| Application number: 2024/90597   |                                                                                  |
| What is the application for?:    | Demolition of existing conservatory and erection of sun room to side with roof t |
| Address of the site or building: | 4, Wrigley Court, Netherton, Huddersfield, HD4 7ED                               |

Drawing number
02 A.

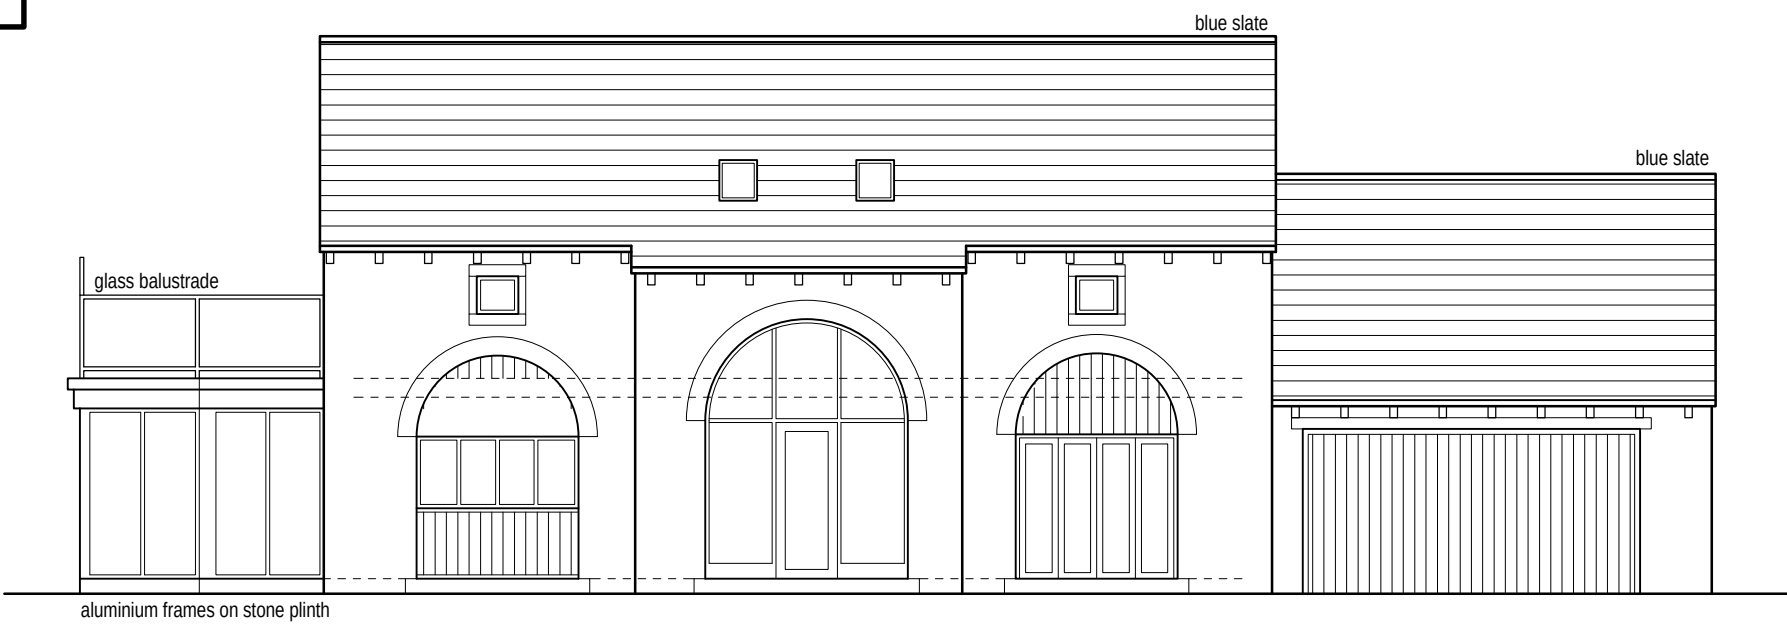
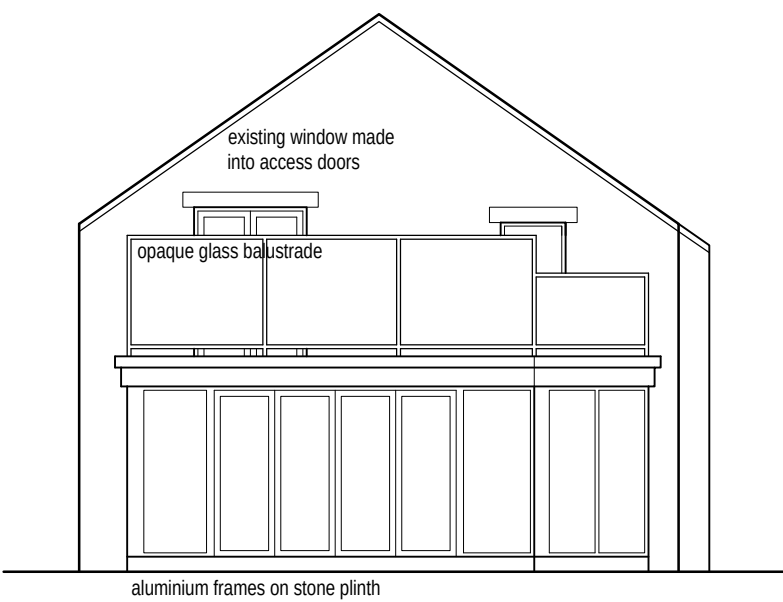
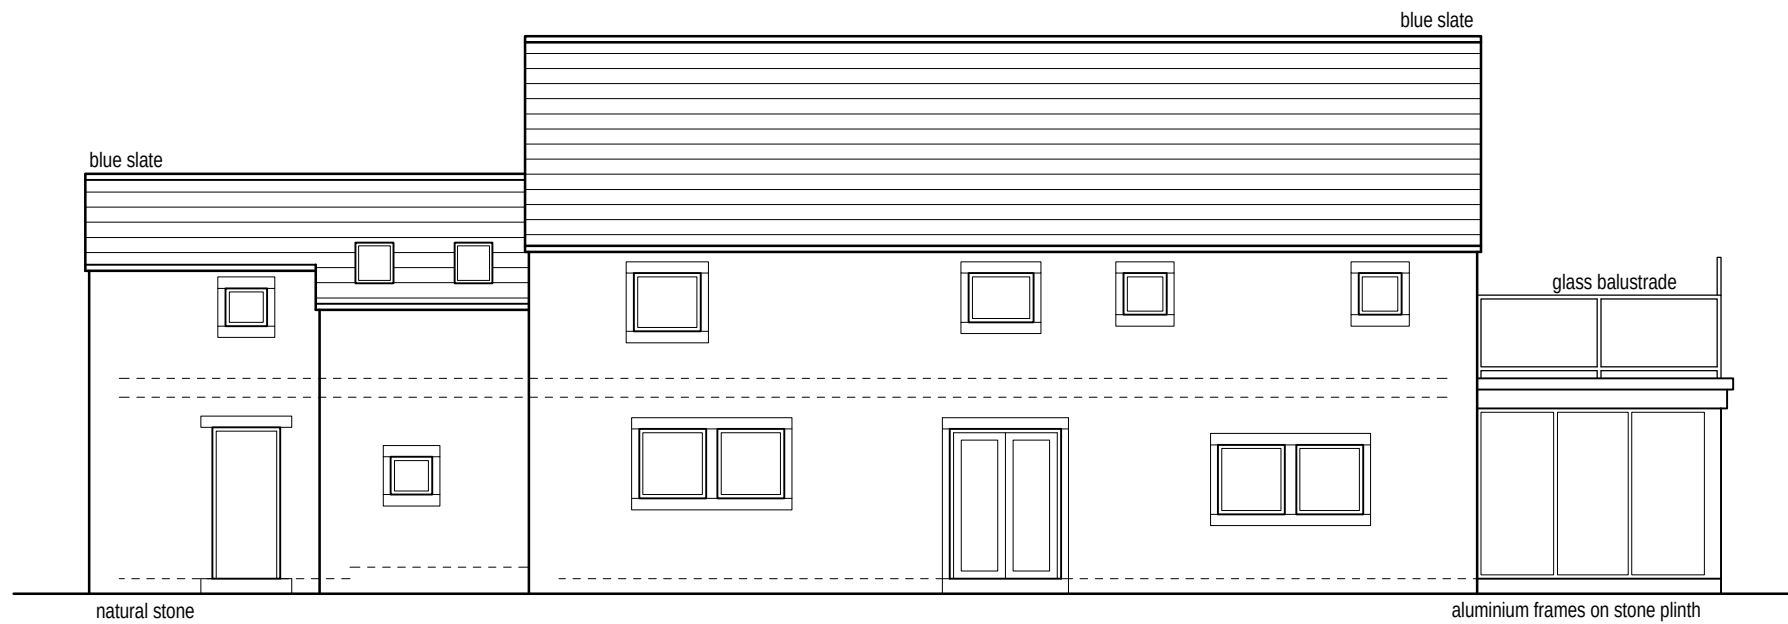
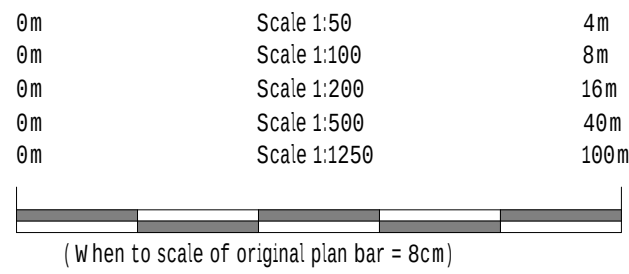
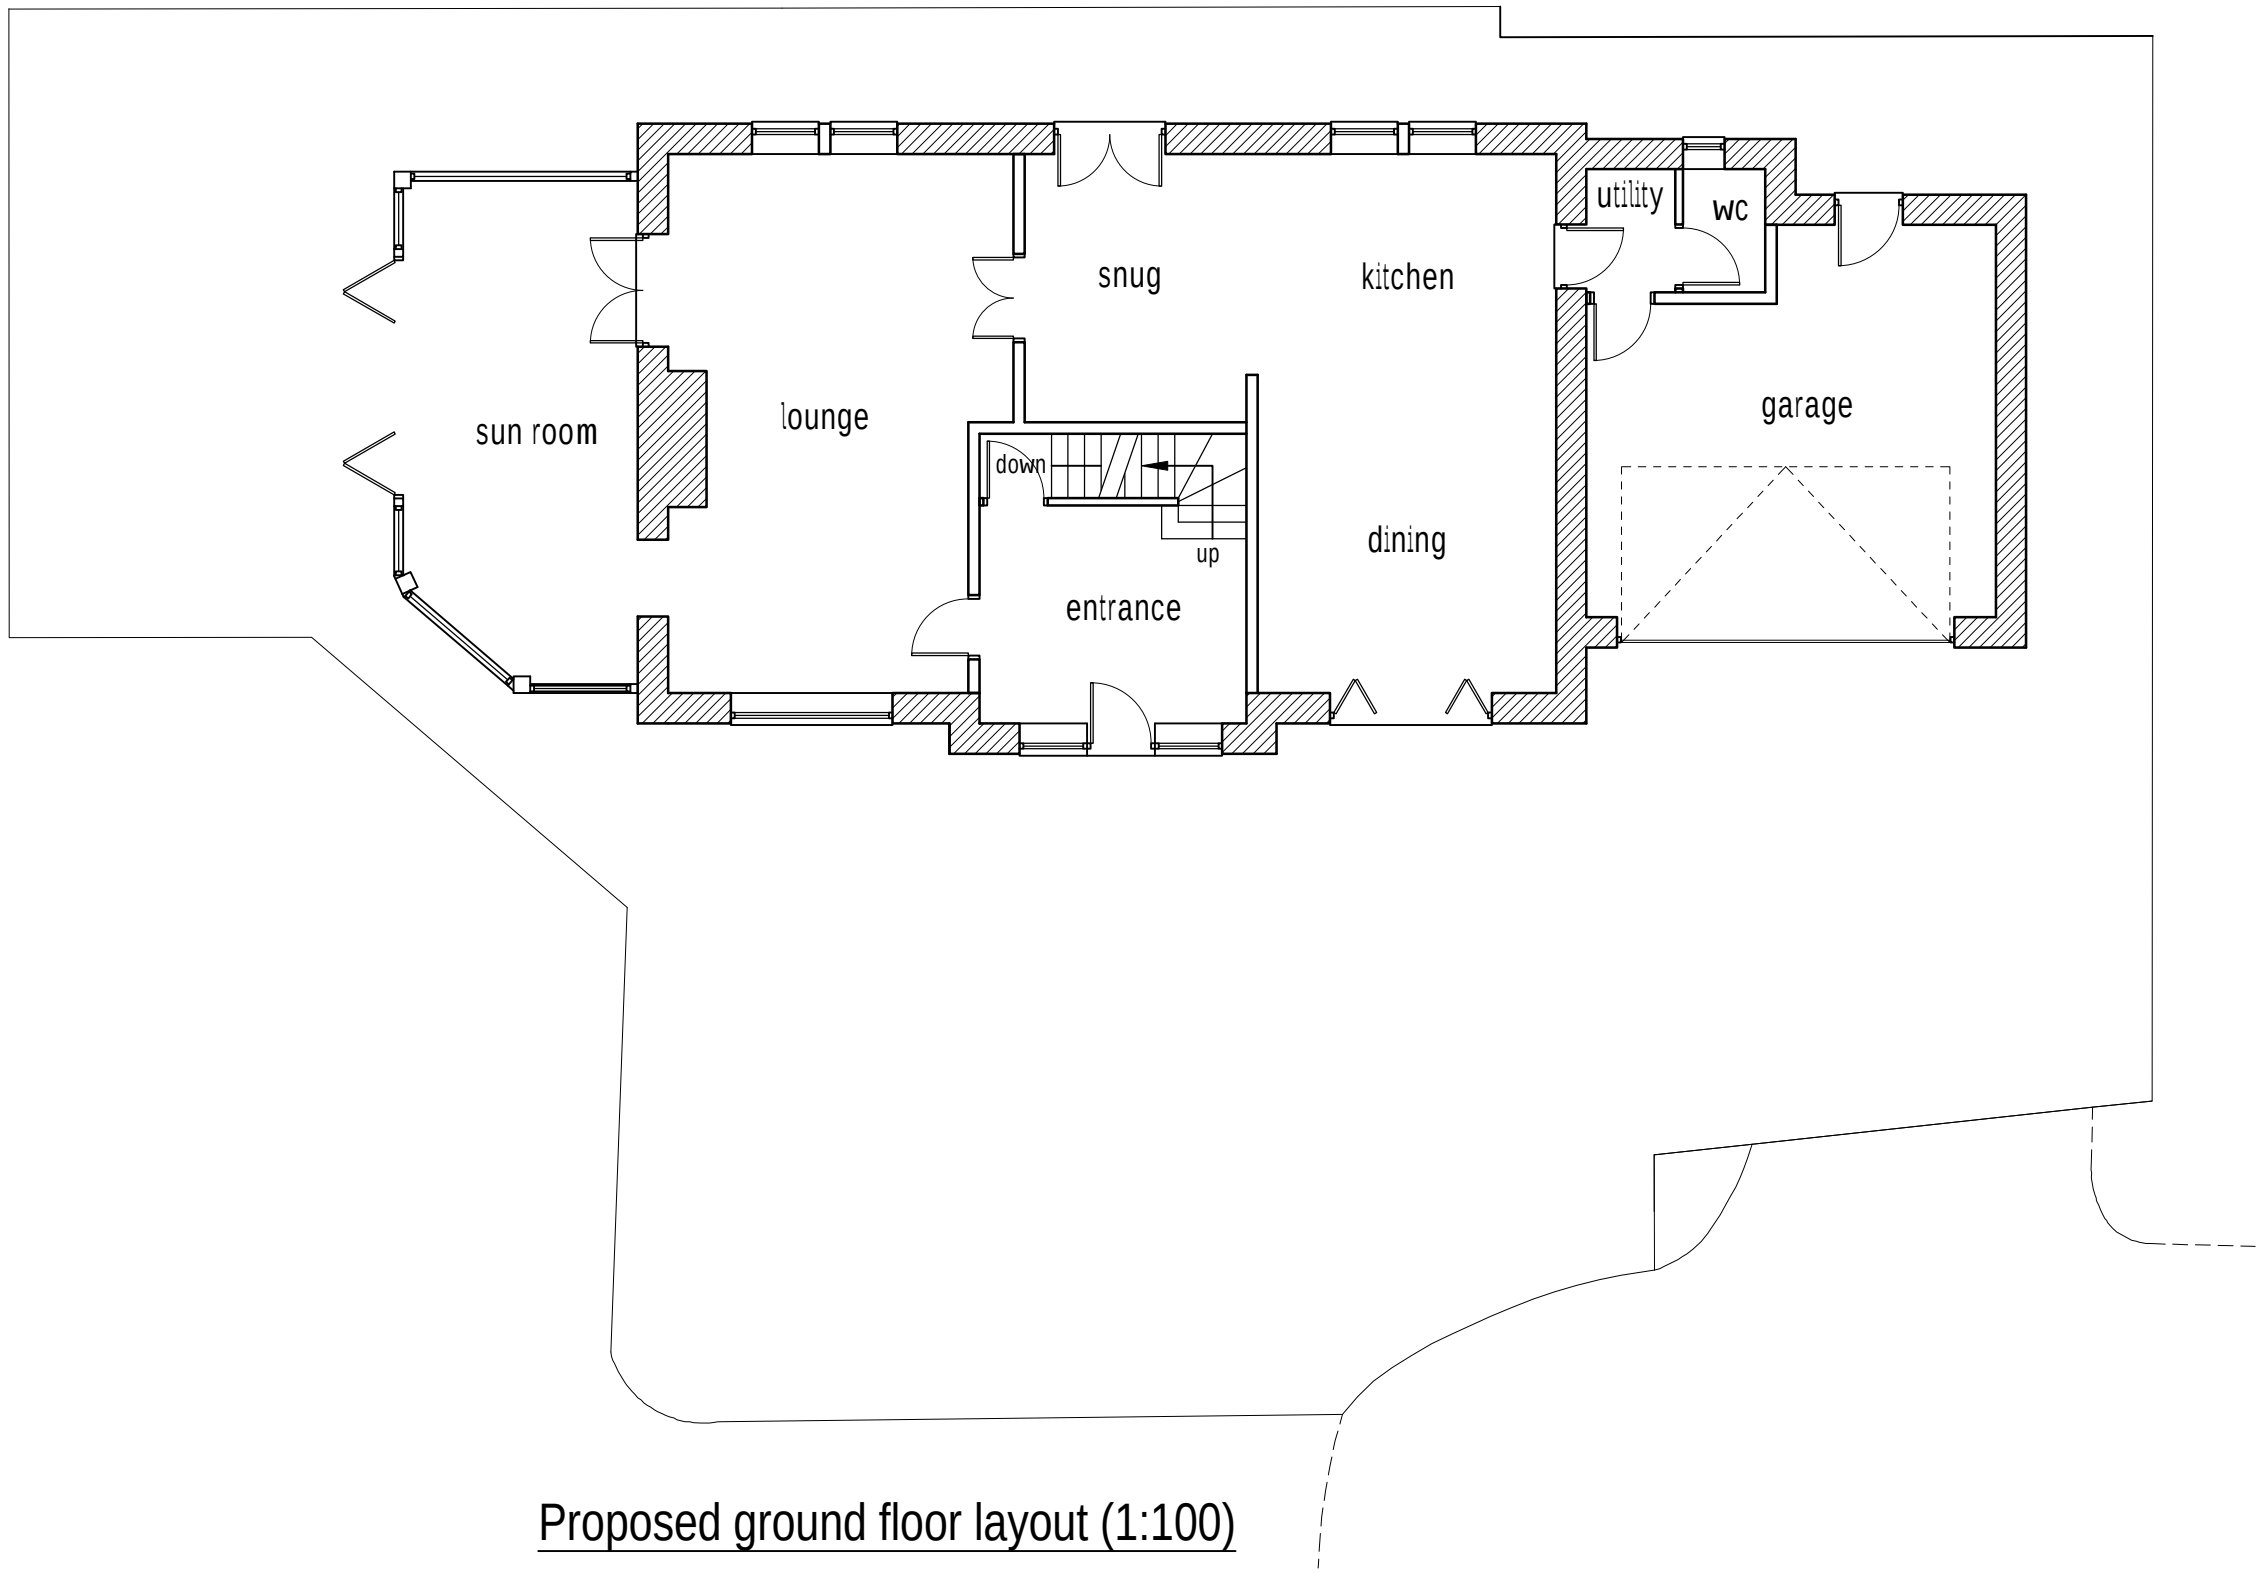
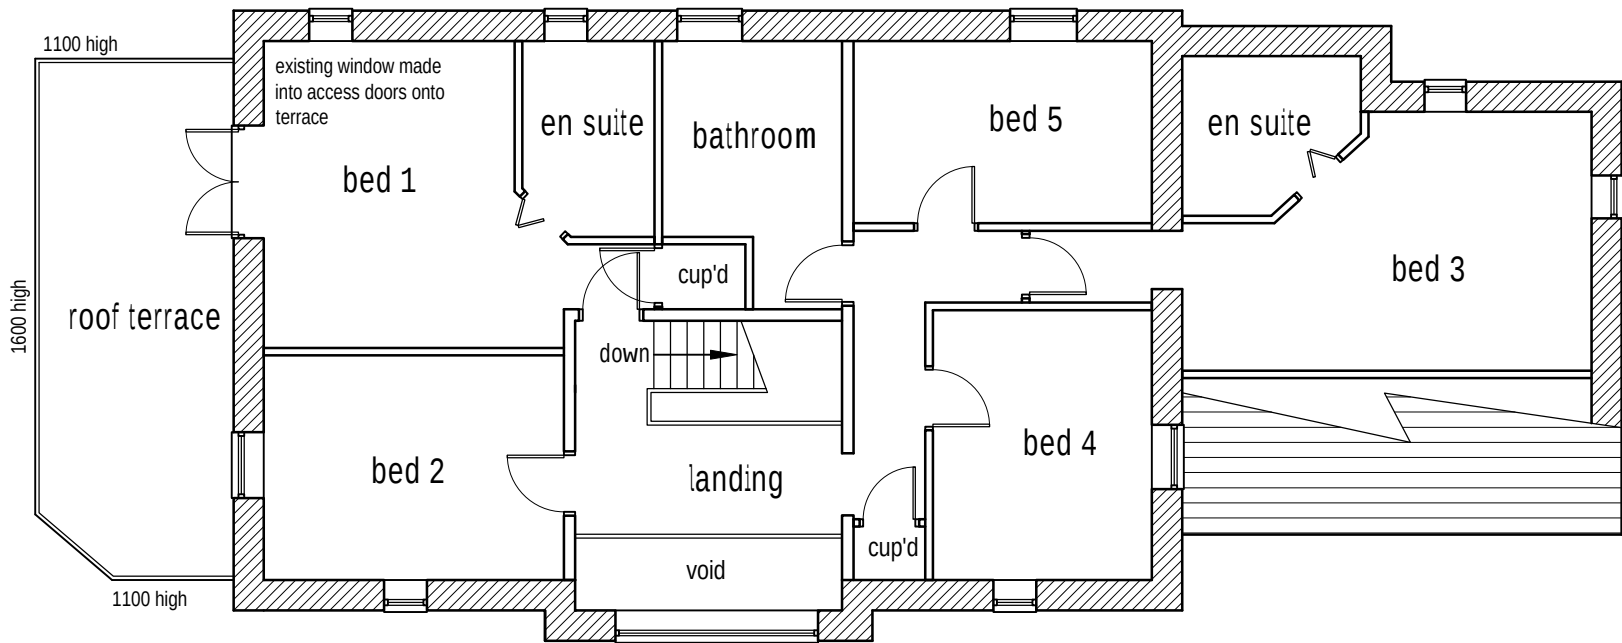
| <p>The roof terrace would affect the privacy of nos 1-3 Cocking Steps Mill, because it would overlook the top front windows of nos 1-3, their front gardens, and the entrance of no 1. Users of the roof terrace would be able to look directly into these areas. The front gardens of the Mill are used a lot in good weather, at exactly the times when the roof terrace would be used.</p> <p>Noise of socialising on the roof terrace would be audible everywhere on Cocking Steps Lane. Past experience (of noise from a hottub) indicates that sound reaches up and down the whole lane.</p> <p>We are keen to preserve both the privacy, and the peace and quiet, of the lane, for the sake of the environment generally, as well as for our own sake. Visitors to the lane comment at once on its privacy and quietness in a crowded, noisy world. But the roof terrace would be in effect a balcony overlooking its neighbours from a height, insensitive and intrusive in a development (Wrigley Close) considerate to its neighbours.</p> |     |
